**KIRKLEES METROPOLITAN COUNCIL  
INVESTMENT & REGENERATION SERVICE**

**DELEGATED DECISION TO DETERMINE PLANNING APPLICATIONS**

| Reference No:         | <b>2024/62/93338/E</b>                                 |
| Description:          | Erection of two storey side extension with front porch |

REAR

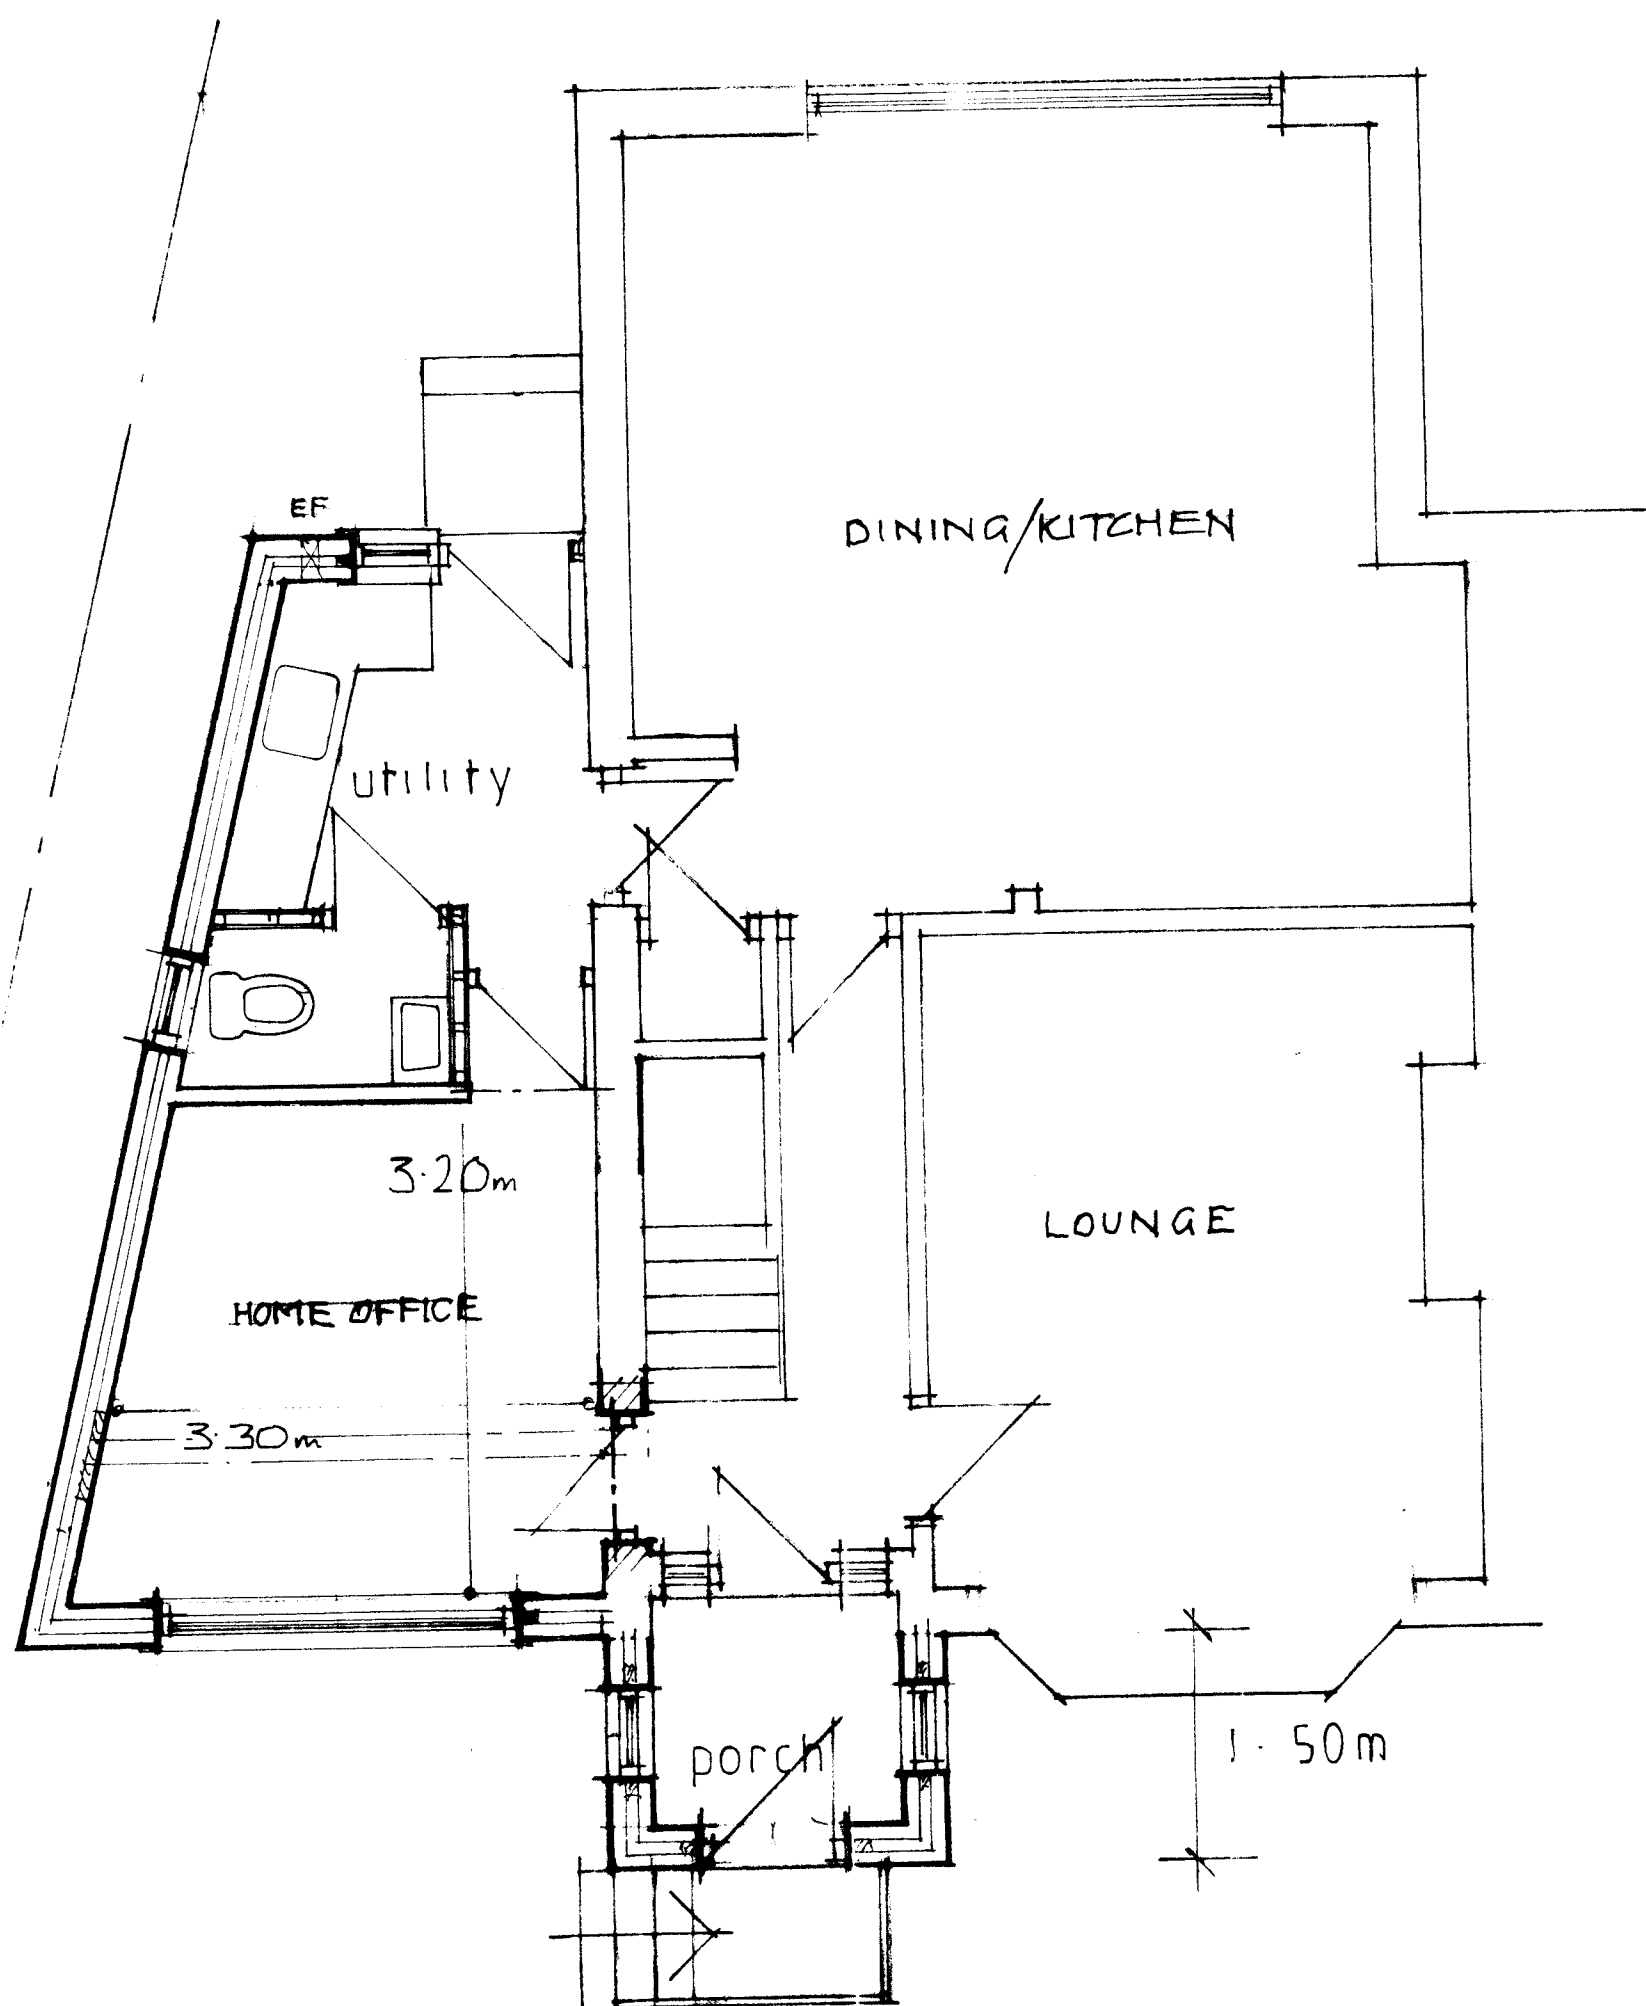
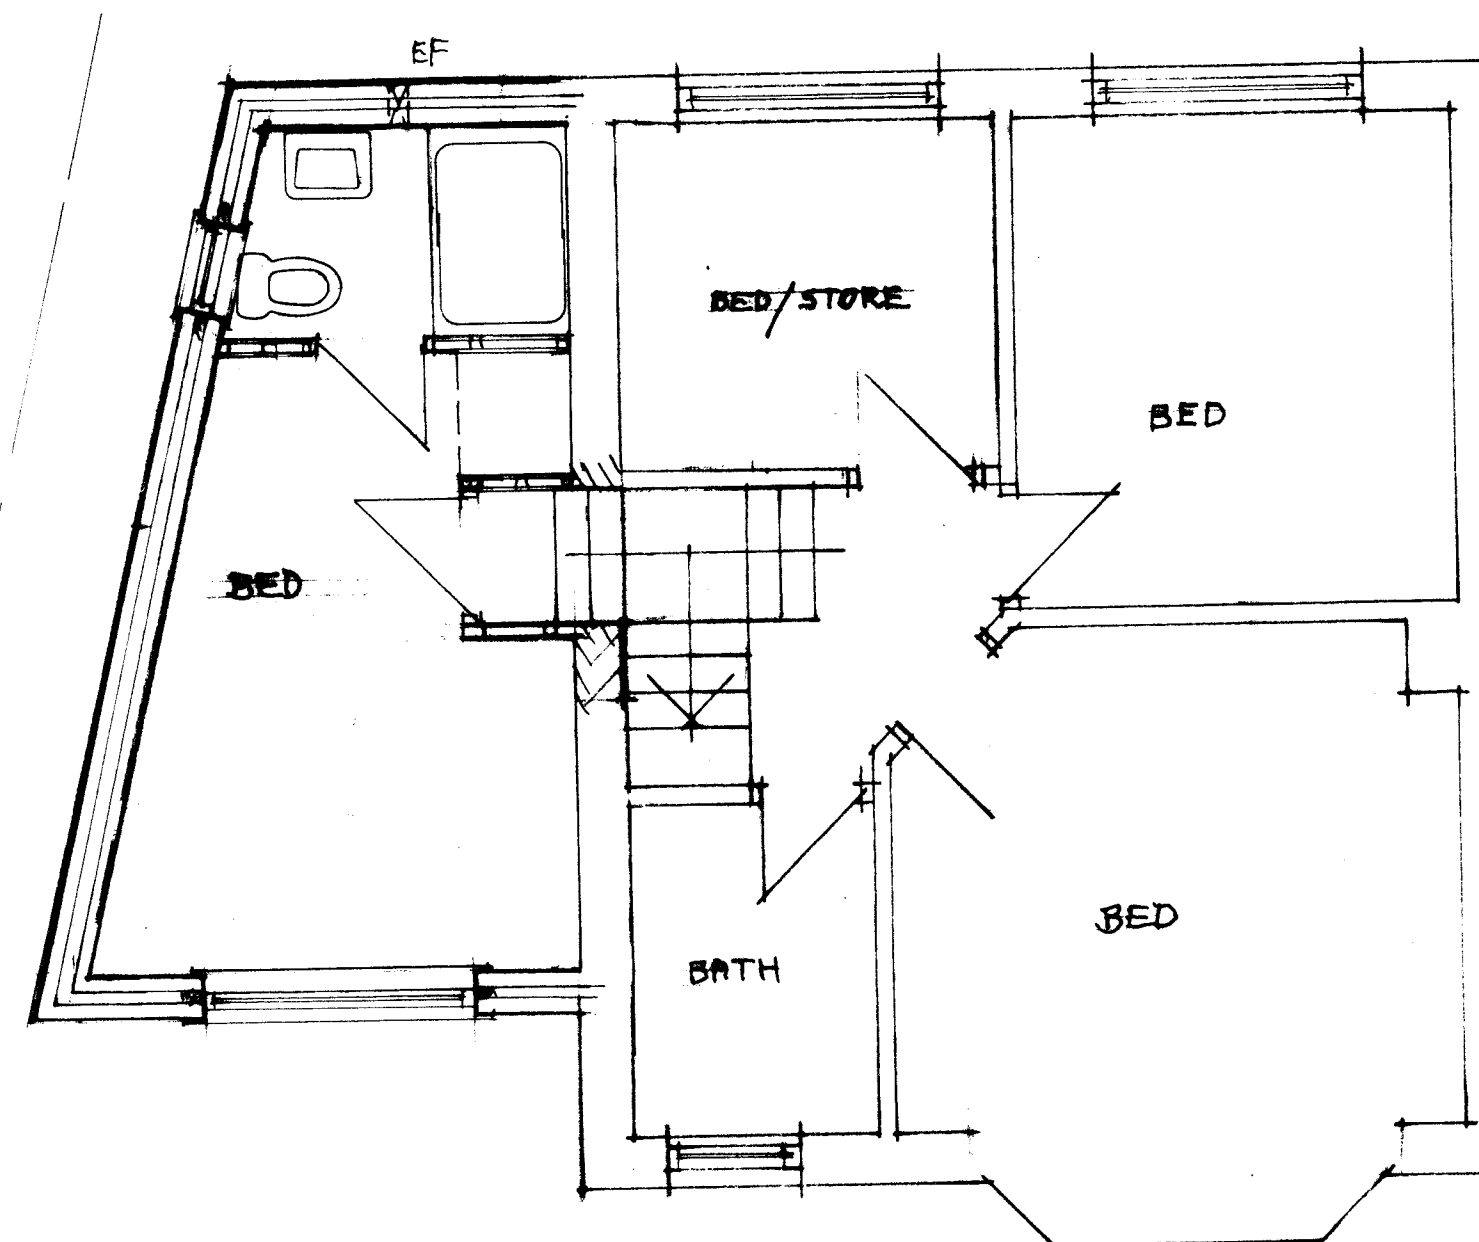
The side extension would project 3.8m from the original side wall at the front corner of the property, tapering to a lesser projection to the rear and angling 1m from the side boundary. The first floor would be set back 1m. The roof over the single storey element would be lean to with a hipped roof over the first floor.

The proposed porch would be of a small scale and acceptable design, and it is noted, would be viewed in the context of the front extension at the adjoining property.

The side extension would be set back from the front elevation of the dwelling with the roof form being set down for the main roof and a gap would be retained to the side boundary. The side extension would be proportionate to the main house. The scale and design are therefore considered to be acceptable. The materials proposed include the use of brick for the walling with tiles for the roof covering which would match the main house. The side extension is therefore considered to be acceptable in terms of visual amenity.

The adjacent property is bungalow with limited openings and which are secondary/non-habitable in nature. Given the spatial relationship, which is angled, and the alignment of the properties, the proposed side extension would have limited potential to result in any overshadowing, overbearing or overlooking. The porch, due to its design and location would also not result in any detrimental impact on residential amenity

The extension proposed would be located on the opposite side of the host property to the adjoining dwelling and as such would have no impact on the amenities of the occupiers of the adjoining dwelling in terms of overshadowing, overbearing or overlooking. The porch, due to its design and location would also not result in any detrimental impact on residential amenity.

The initially submitted plans raised concerns in terms of the roof form proposed being out of character with the main house. Amended plans have been sought and received which altered the roof form to a hipped roof. As the alterations reduced the level of development, the amended plans have not been advertised.
